An
Bord
Pleanála

Inspector's Report

ABP-317874-23

Extraction of sand and gravel from quarry. An Environmental Impact Assessment Report (EIAR) and a Natura Impact Statement (NIS) have been submitted.

Longitudinal Section of Haul Road
Scale: NTS

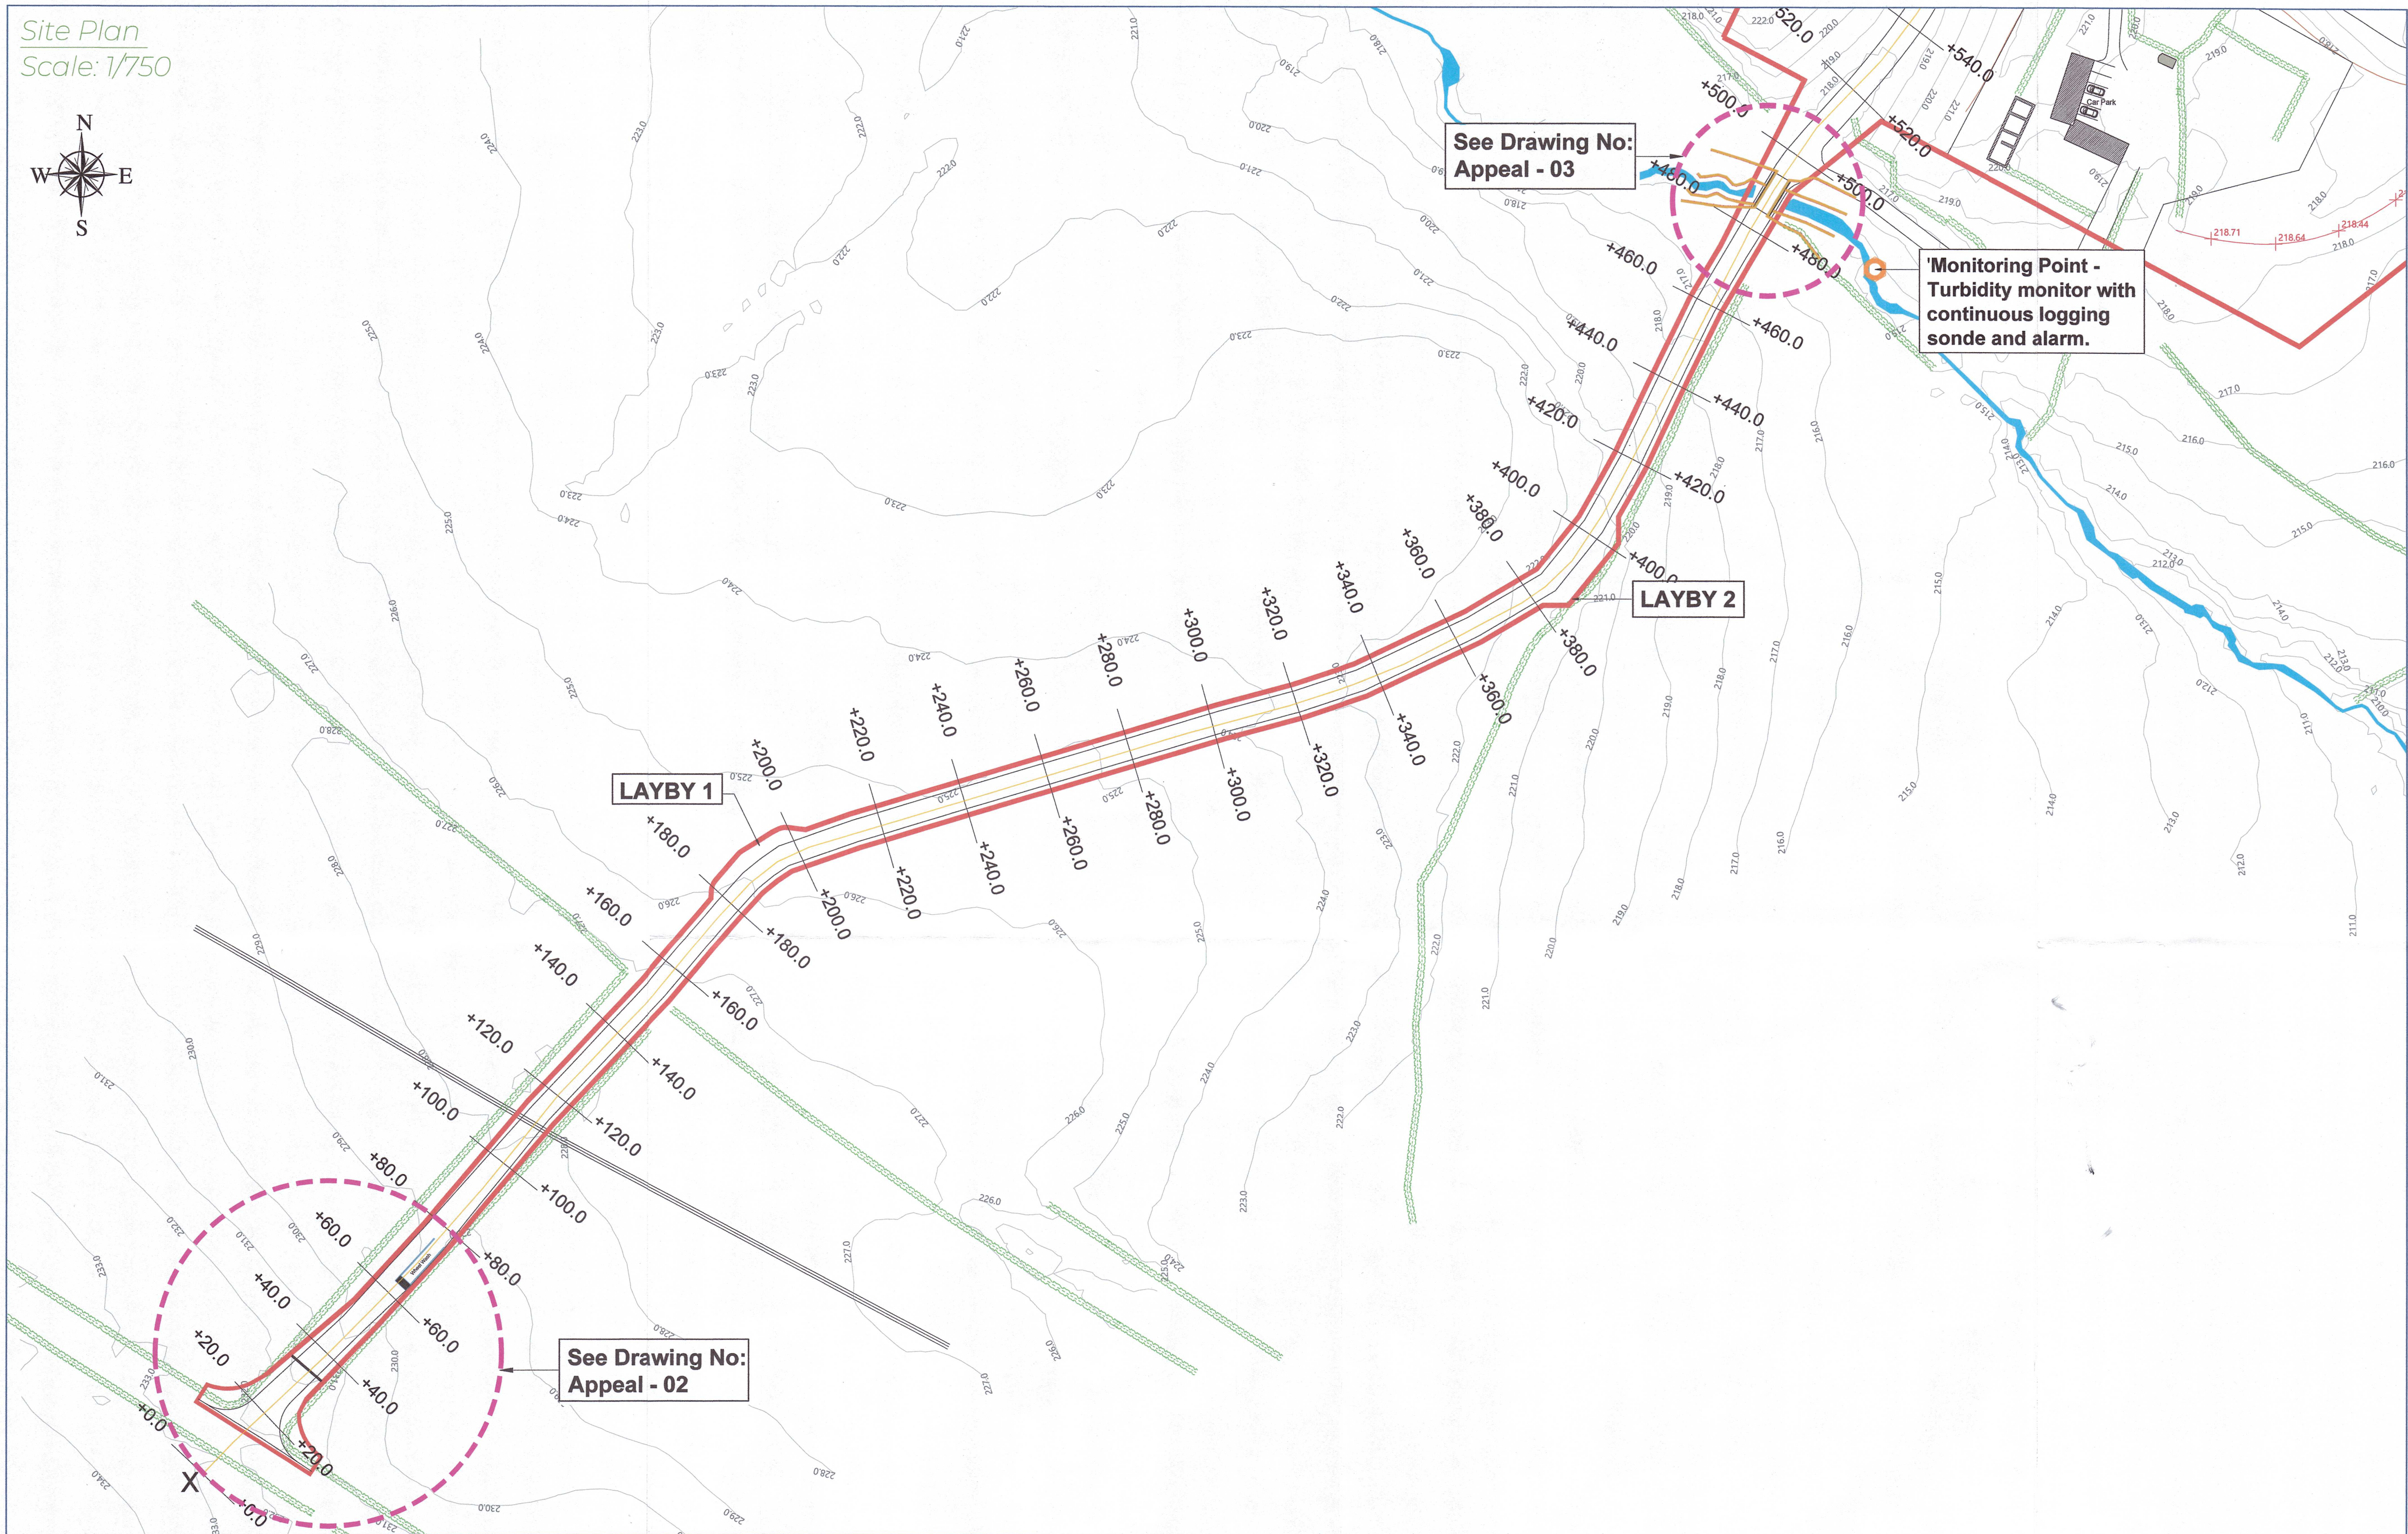
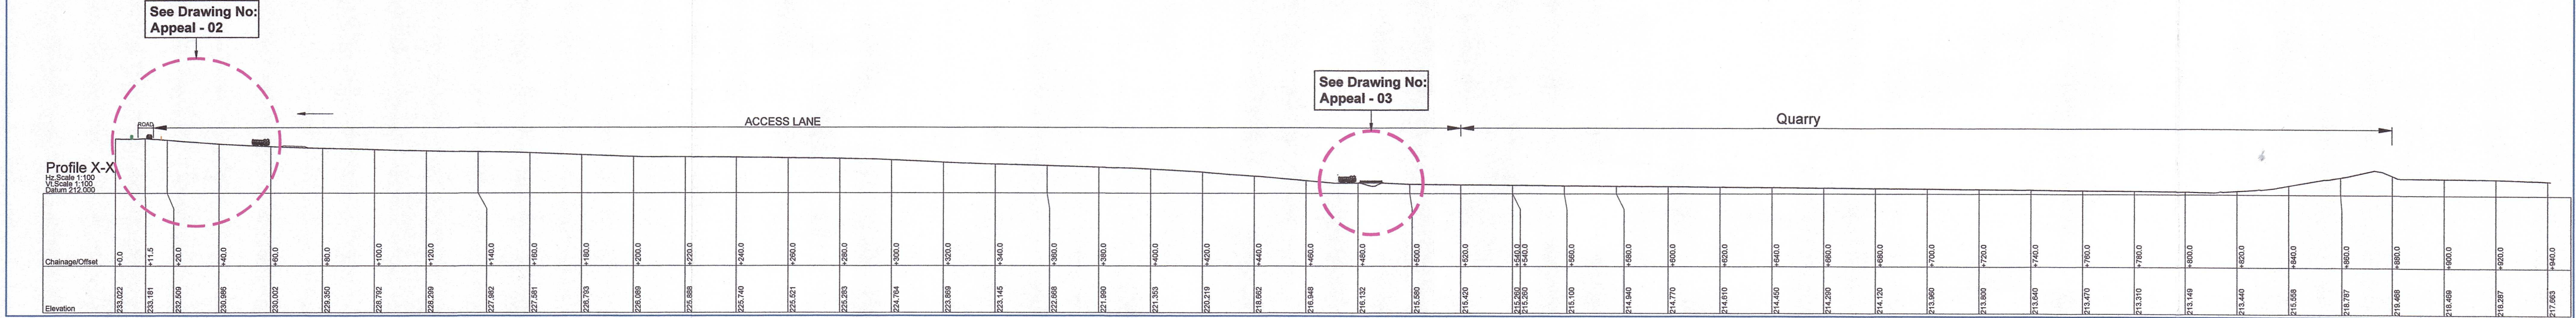
- The Haul Road Section Drawing No. AI-04 proposes a tarmacked surface from the edge of the R756 to the relocated wheel wash. A new gate is set back 17m from the edge of the R756 with an Aco drain set back 20m.

SILT FENCE SECTION AT BRIDGE

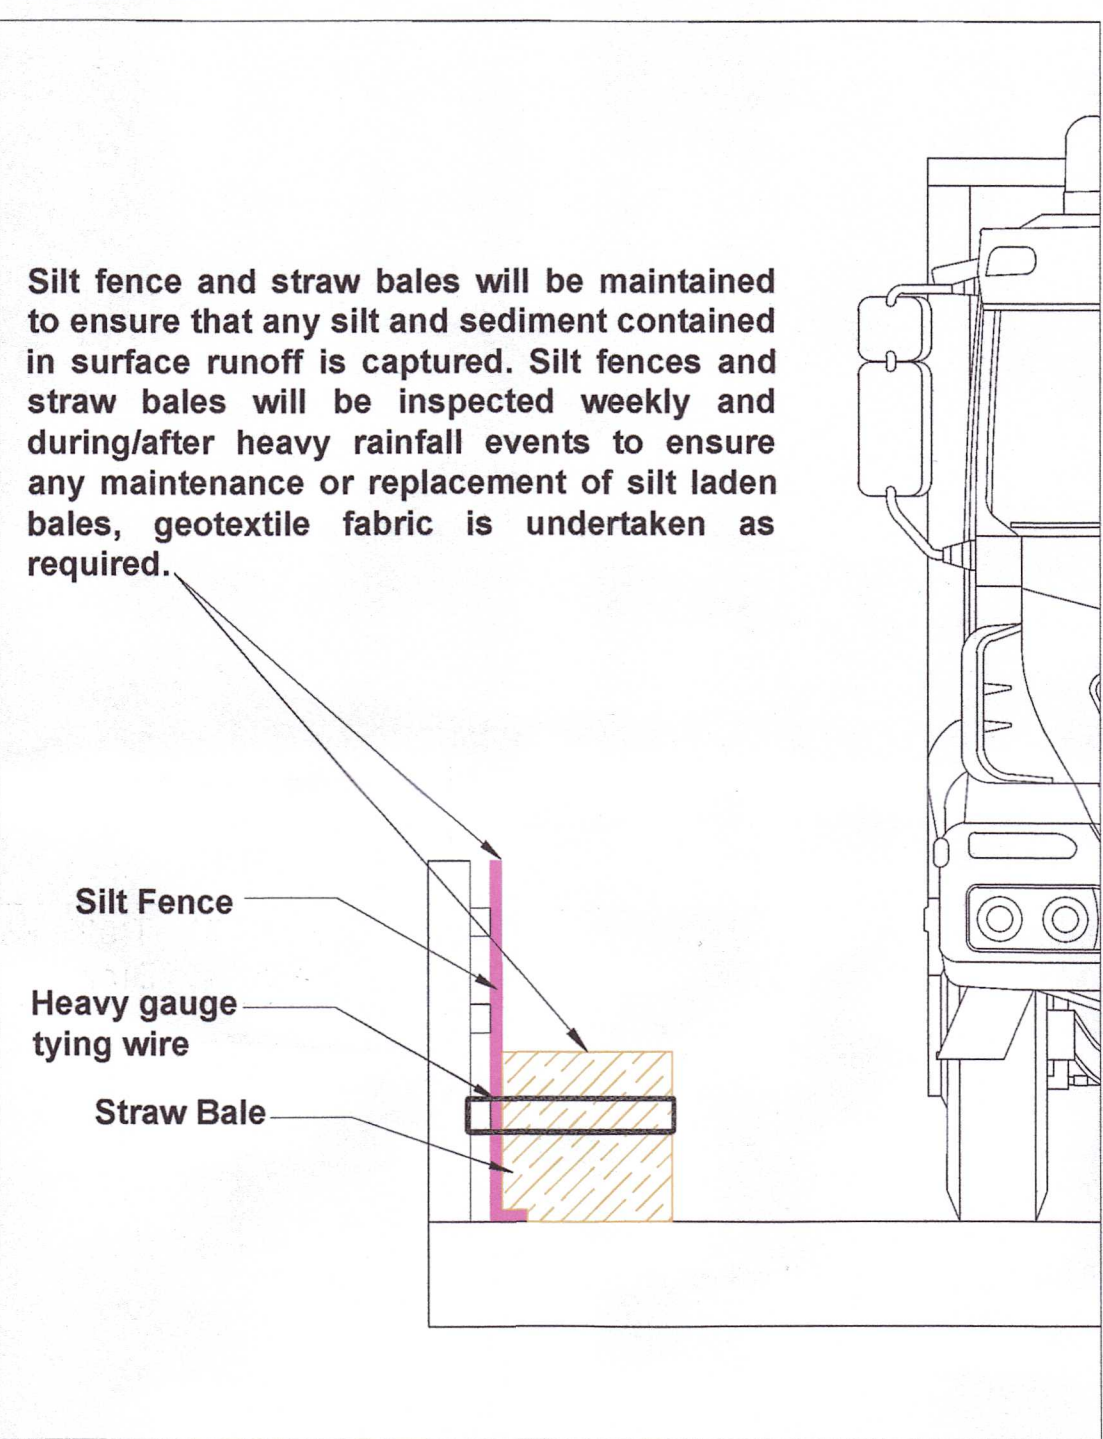
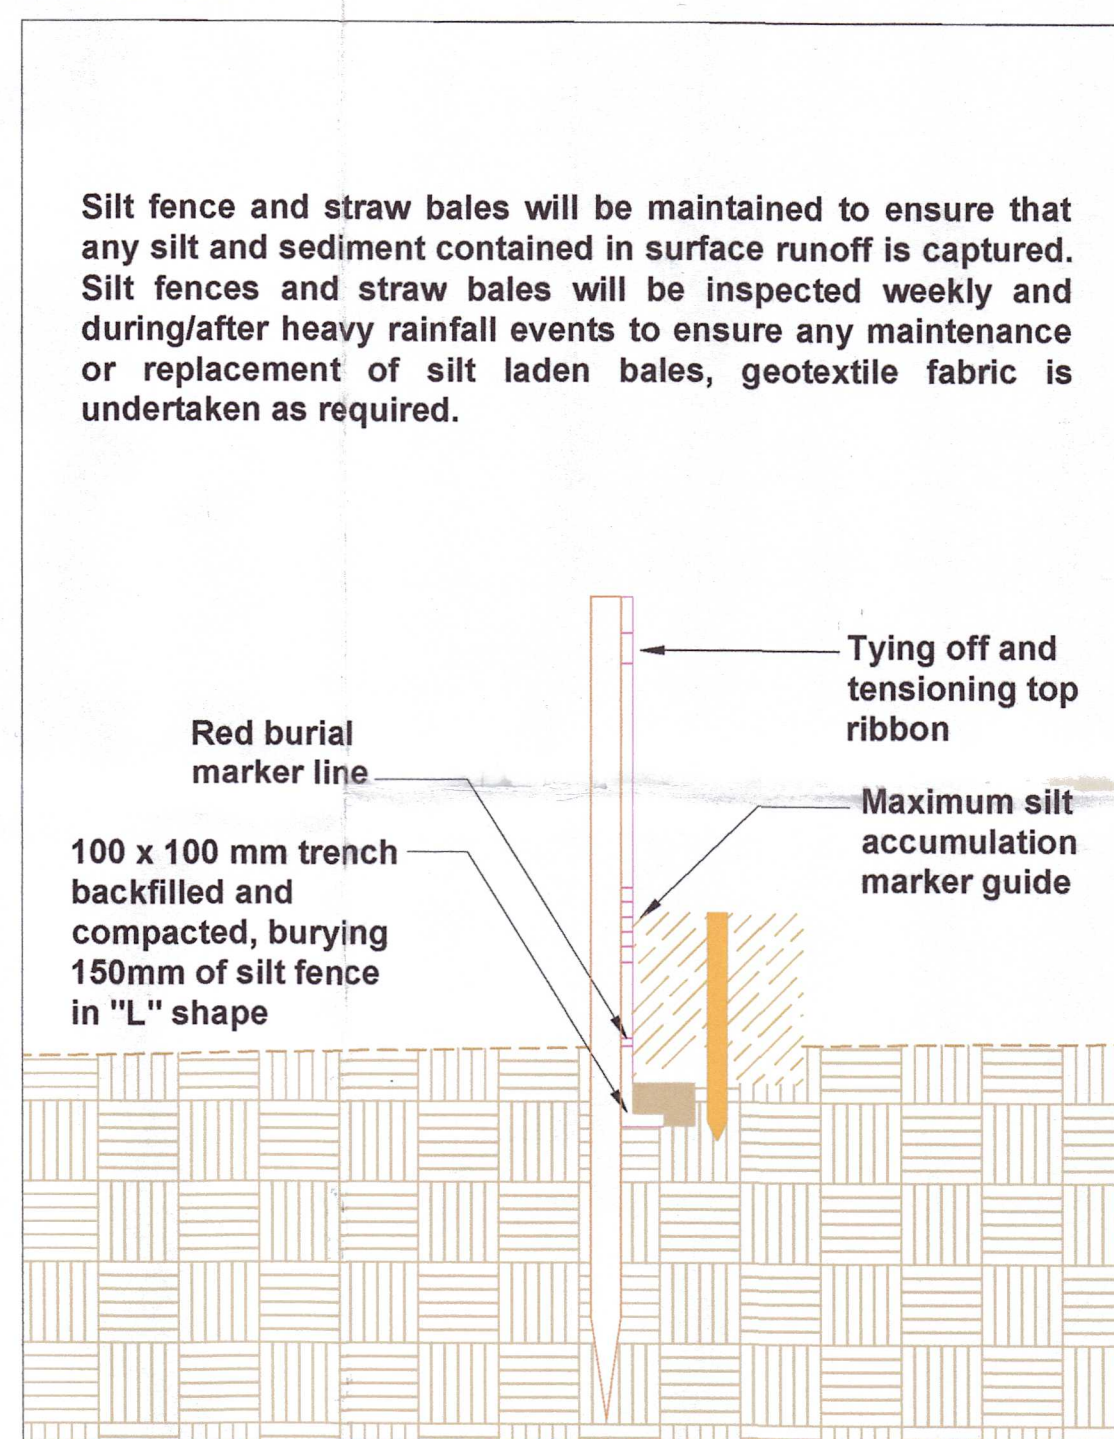
- In terms of the bridge details, it is proposed to install 4x10m lengths of silt fencing upstream and downstream running parallel to the riverbanks at the top and bottom of the bank, in addition to the already specified silt fencing attached to the bridge as originally proposed.
